STATE OF NORTH CAROLINA
DEPARTMENT OF TRANSPORTATION

February 16, 2006

Subject: **APPLICATION REVISION for Individual Section 404 and 401 permits for TIP R-2616** for the proposed widening of US 601 from the South Carolina State Line to north of Marion Lee Road (SR 2105) south of Monroe in Union County; NCDOT Division 10. Federal Project No. STP-NHS-601(4), State Project No. 8.1690303, WBS Element 34485.1.1.

SITE 24 -L- STA. 534 + 20

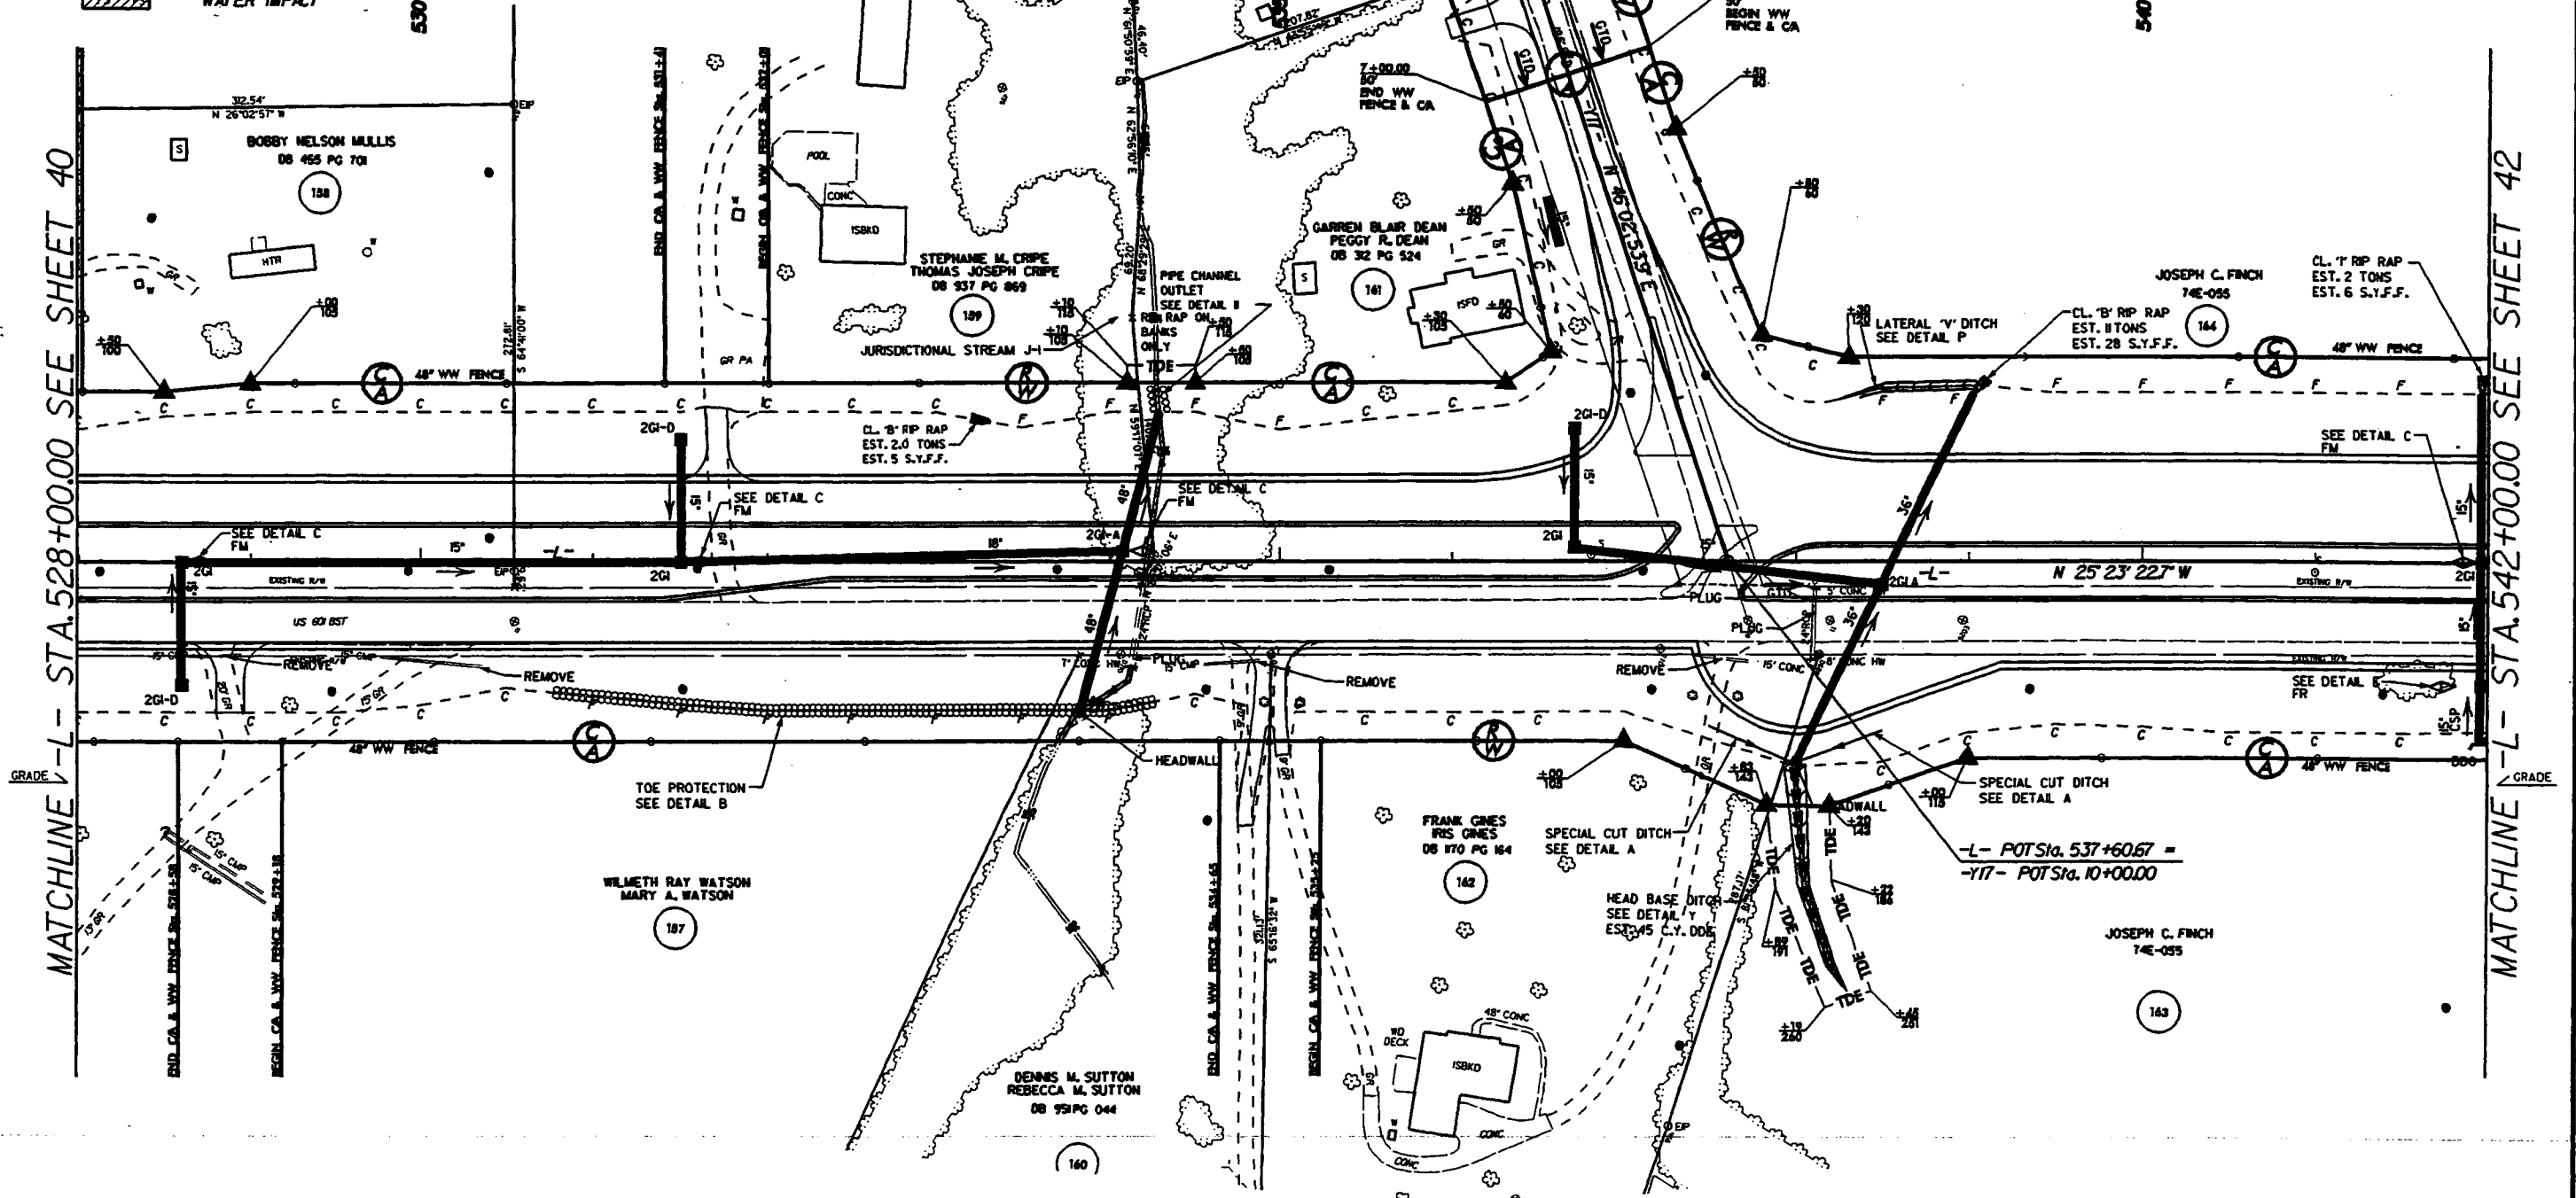
Site 24 (Permit application page 53): The temporary stream impacts have increased by 10 feet (from 20' to 30'). This change is necessary for the temporary de-watering activities for the installation of the box culverts.
